From: Thomas Roberts [REDACTED]
Sent: 25 February 2021 11:14
To: Simon Davis <Simon.Davis@arun.gov.uk>
Cc: Ian Johnson [REDACTED]
Subject: Re: Y/11/21/NMA Bonhams Field

Subject: Y/11/21/NMA Bonhams Field

CLIENT	Seaward Properties Ltd		PROJECT	Bonhams Field, Yapton	
SCALE	1 : 100	(A1 ORIGINAL)	DRAWING	Plots 42-47 Proposed Plans	
DRAWN DATE	DA 11.10.18	18076	P122	B

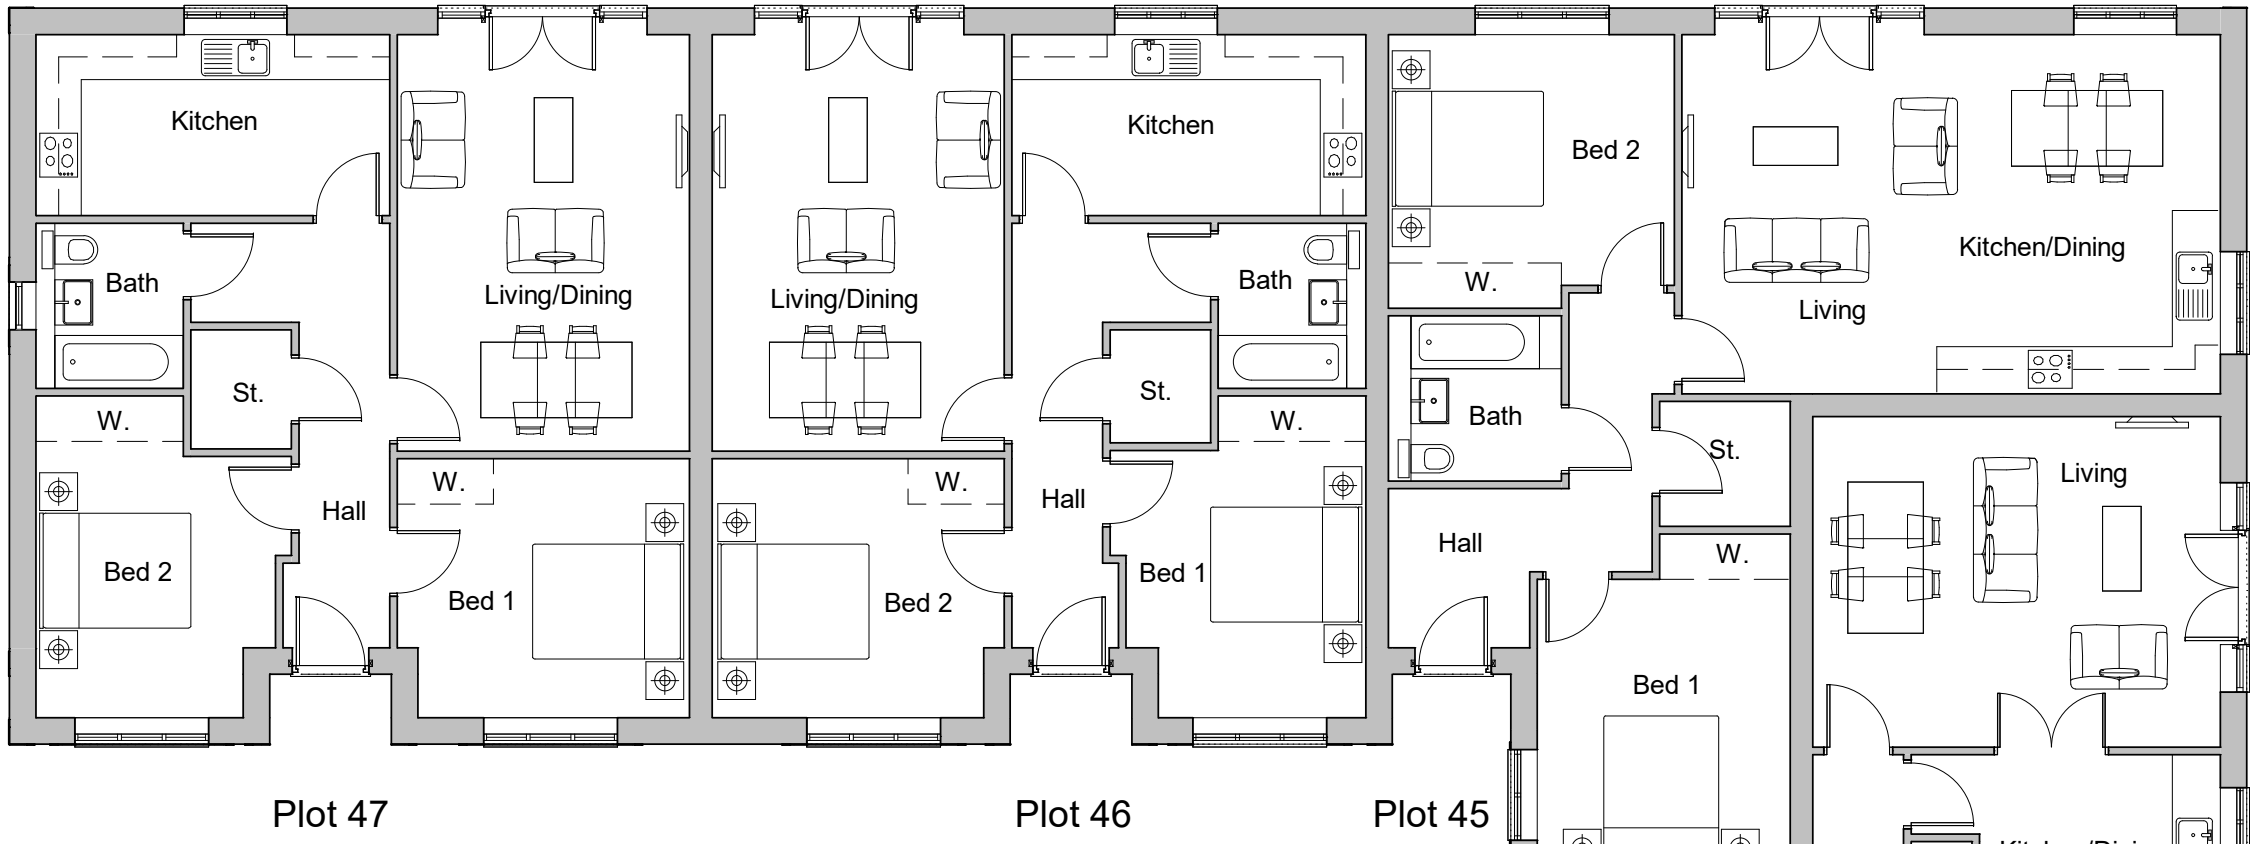
I note that application description is solely regarding the changes to the footprint of plots 42-47. However, the covering letter also refers to additional disabled parking bays. Yet when I compare the approved plans to those now provided, there would appear to be a reduction in the amount of spaces marked as disabled (1 shown on the new plan, 4 on the Rev V plan approved by Y/63/19/RES).

Can you advise whether you want me to consider the change in disabled spaces as part of this NMA. If you do then I think we need the plans amended to indicate where the disabled spaces are and to make it clear which are additional ones. If you do not then I still think we need amended plans but in this case to show the disabled spaces marked as before.

Thank you for your email. Apologies for the mix up on the cover letter, in terms of the disabled parking spaces we are in fact reducing the number of disabled spaces. Details are as below;

When we amended plots 42-47 to become M4(2) compliant we removed the 3 spaces near plot 42-56. This is because parking at M4(2) dwellings must have a space that can be widened to 3.3m. We have designed the car park spacing that each plot has a space that is already 3.3m wide. The purpose of M4(2) is to make the dwellings potentially more suitable for a range of occupants, including some wheelchair users. So the parking has been improved overall.
